CITY OF ALBUQUERQUE

Re: Chick-fil-A
NWC of Coors & St. Joseph Dr. NW 87120
Traffic Circulation Layout
Engineer's/Architect's Stamp 10-16-18 (G11D069C)

Based upon the information provided in your submittal received 11-19-18, the above referenced plan cannot be approved for Building Permit until the following comments are addressed:

SHEET TITLE
SITE PLAN &
TRAFFIC
CIRCULATION
LAYOUT

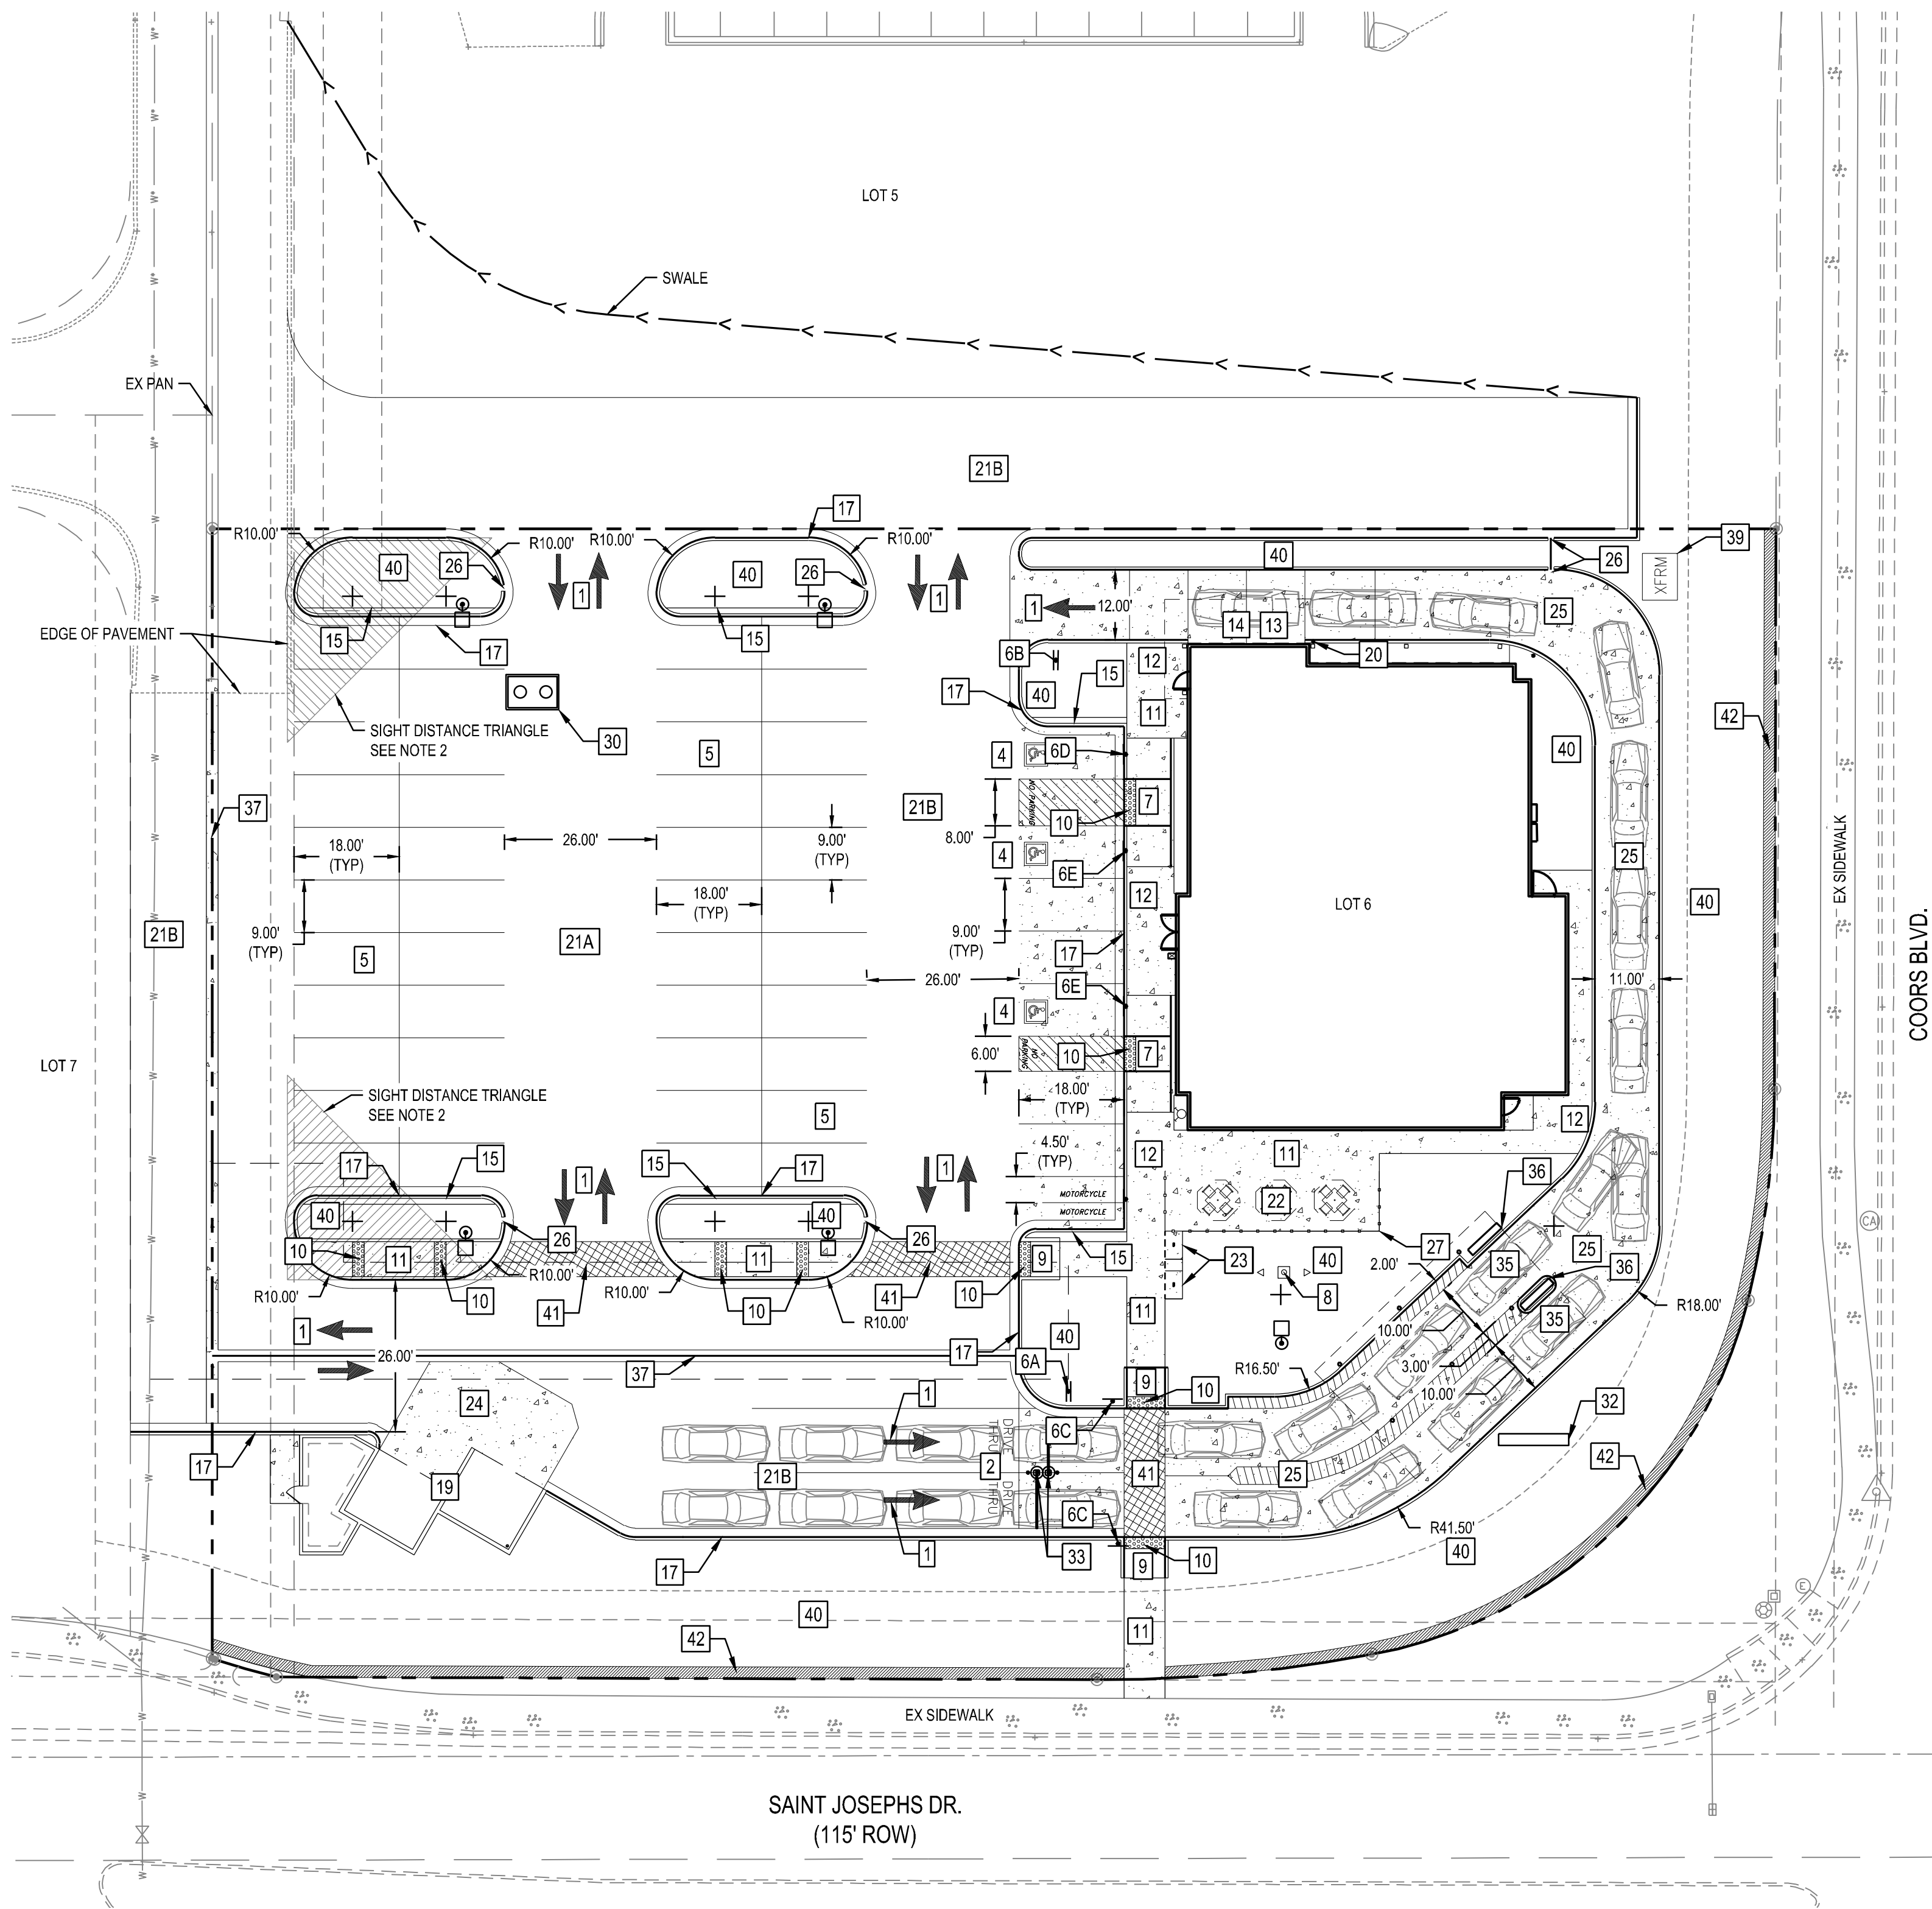
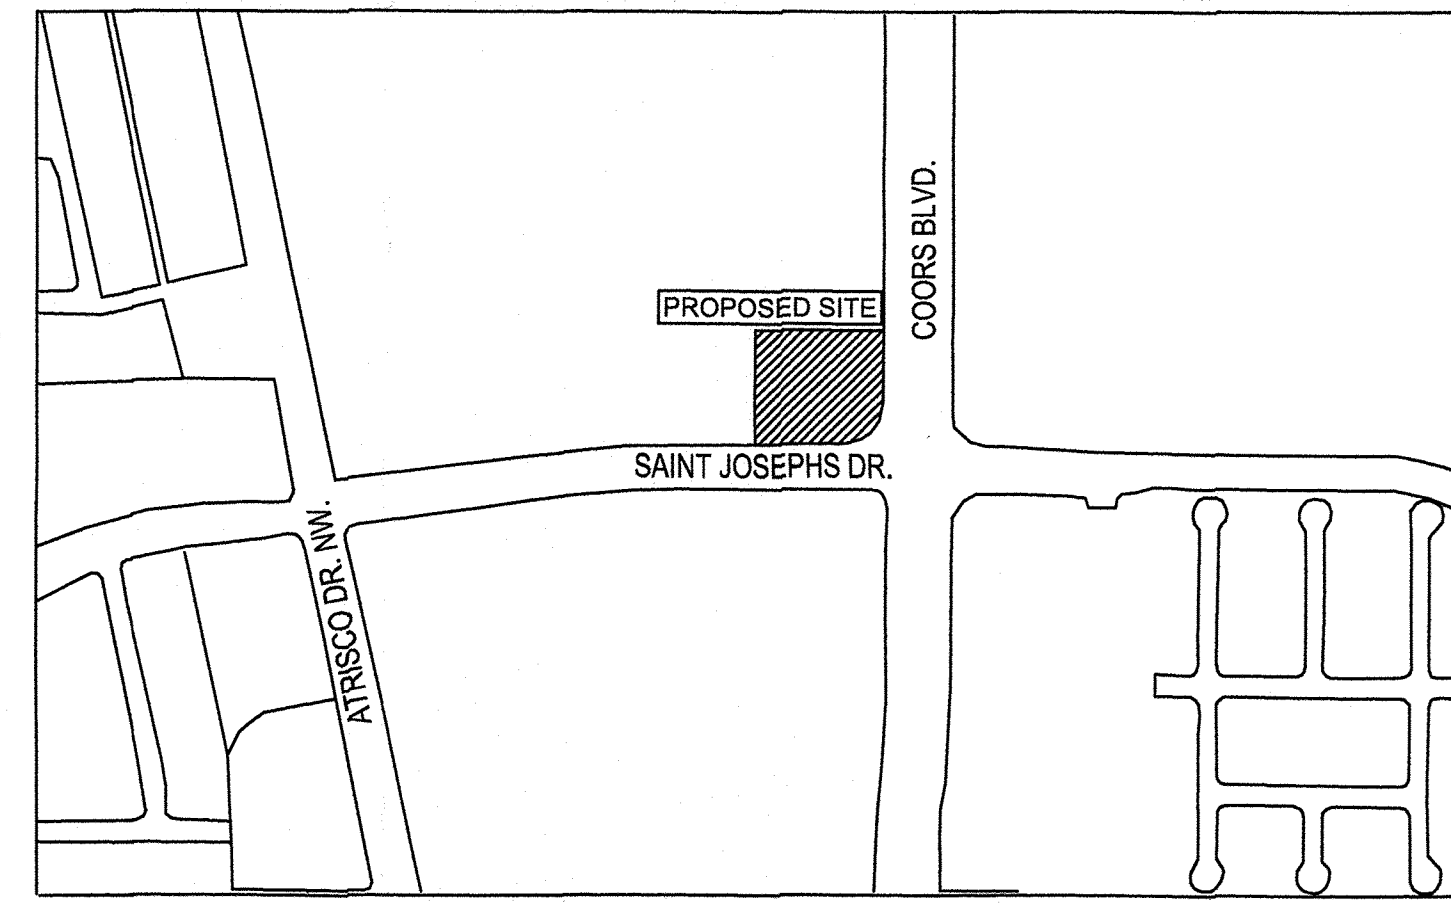
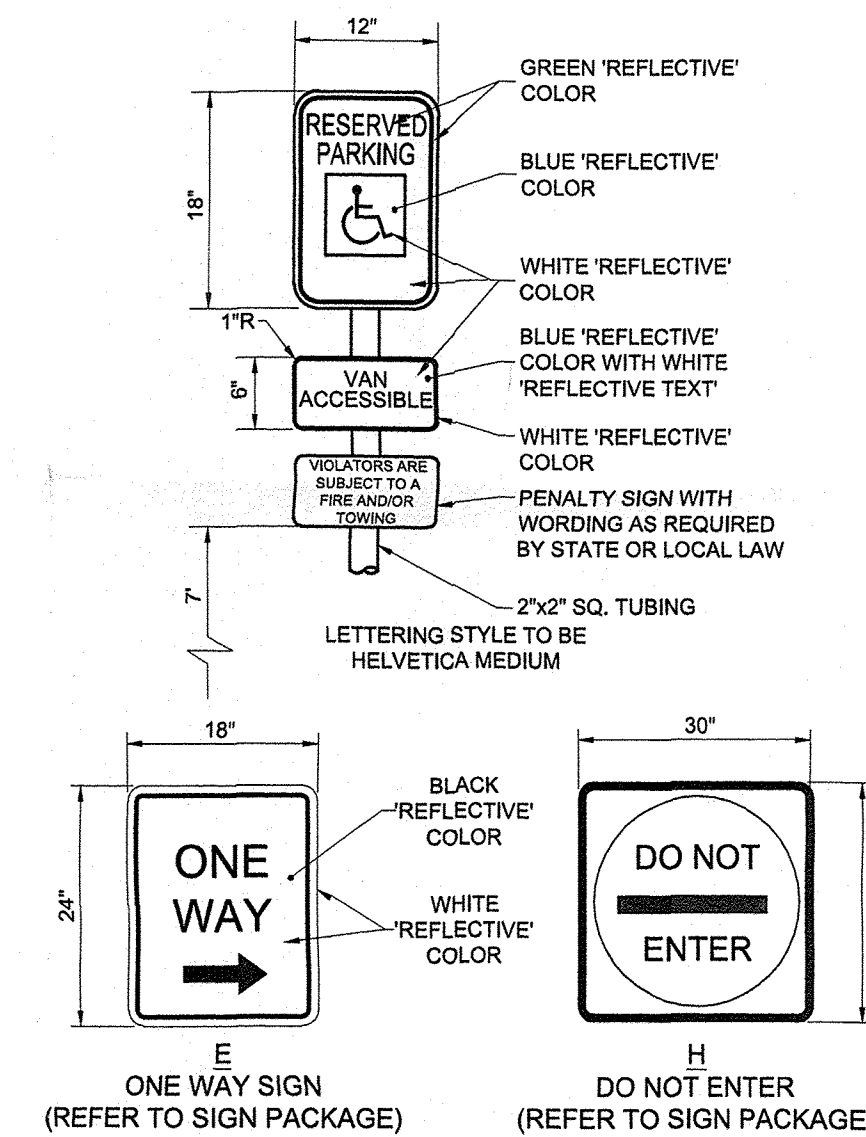
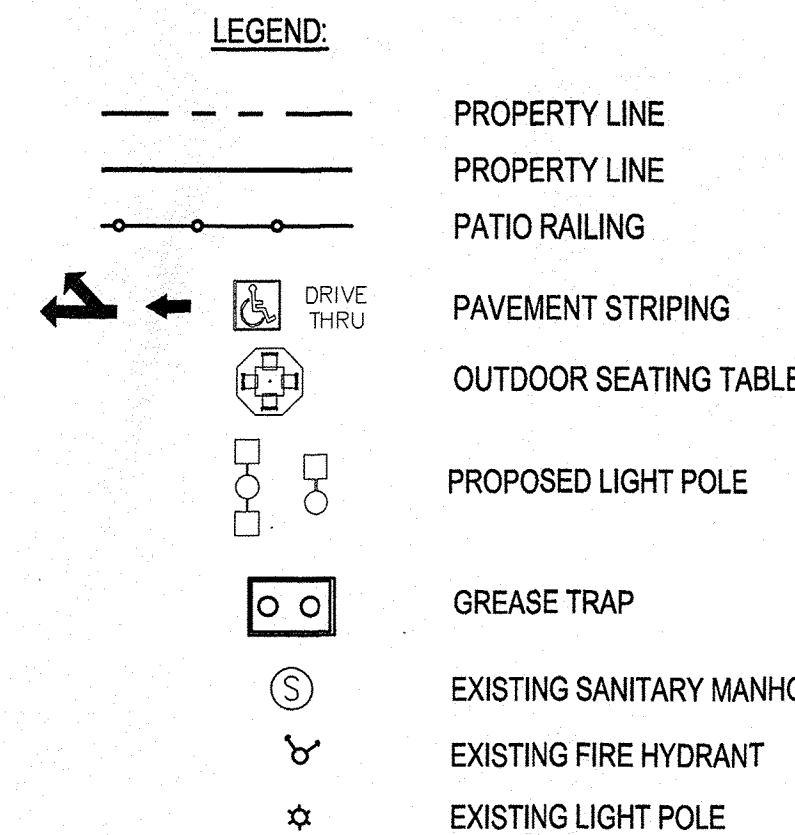
1. Please review and revise plan to provide all information listed on the attached Traffic Circulation Layout checklist.
2. List the number of bicycle spaces required by the IDO.

3. Please check parking calculations.
4. Please list the width and length for all existing and proposed parking spaces. Some dimensions are not shown.
5. The traffic circulation layout must be stamped, signed, and dated by an engineer or architect licensed in the state of New Mexico.

6. Van accessible aisles should be 8ft wide; all others should be 5ft wide. Some dimensions are not shown.
7. Please add a note on the plan stating "All improvements located in the Right of Way must be included on a public work order.

8. Show sidewalks and access to the site.
9. The ADA accessible parking sign must have the required language per 66-7-352.4C NMSA 1978 **"Violators Are Subject to a Fine and/or Towing."** Please call out detail and location of HC signs.

10. Motorcycle parking spaces shall be designated by its own conspicuously posted upright sign, either free-standing or wall mounted per the IDO. Please dimension motorcycle parking.

11. Show all drive aisle widths and radii. Some dimensions are not shown.
12. Service vehicle and/or refuse vehicle maneuvering must be contained on-site; provide a copy of refuse approval.
